September 10, 2023
Project No. T-8718

Subject: Response to City of Mercer Island Comments
3036 – 67th Avenue SE
Mercer Island, Washington

References: 1. Geotechnical Report, 3036 – 67th Avenue SE, Mercer Island, Washington, Project No. T-8718, prepared by Terra Associates, Inc., dated August 22, 2022, revised April 21, 2023
3. Geotechnical Peer Review Comments, prepared by City of Mercer Island, dated August 2023

JOB NUMBER:

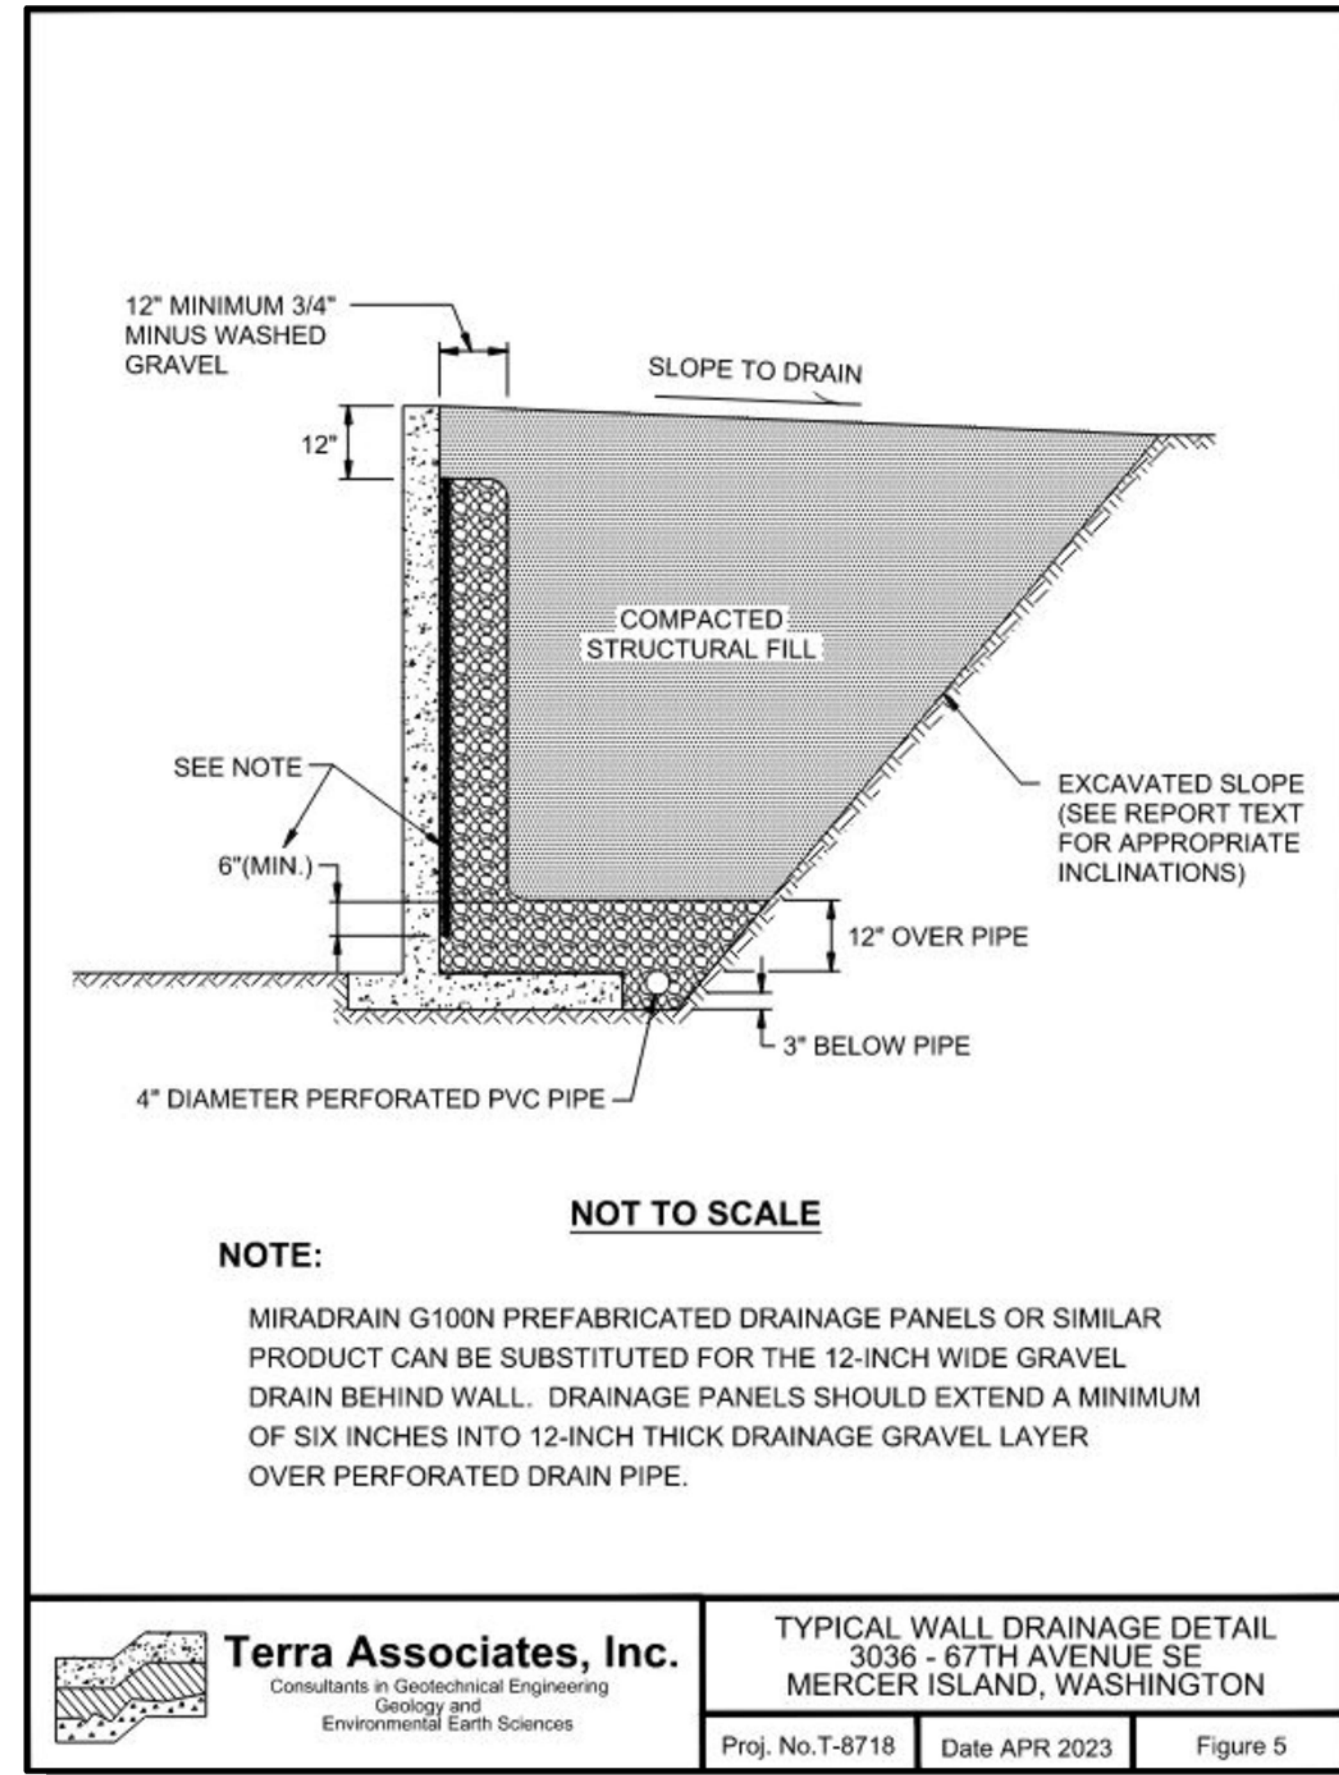
Please revise the project plans (e.g. temporary grading plans, depth of interceptor trench, etc.) and revise stability analyses to include the potential overexcavation depths required to remove the loose soils below the foundations.

The stability analysis has been updated to include the potential over excavation.
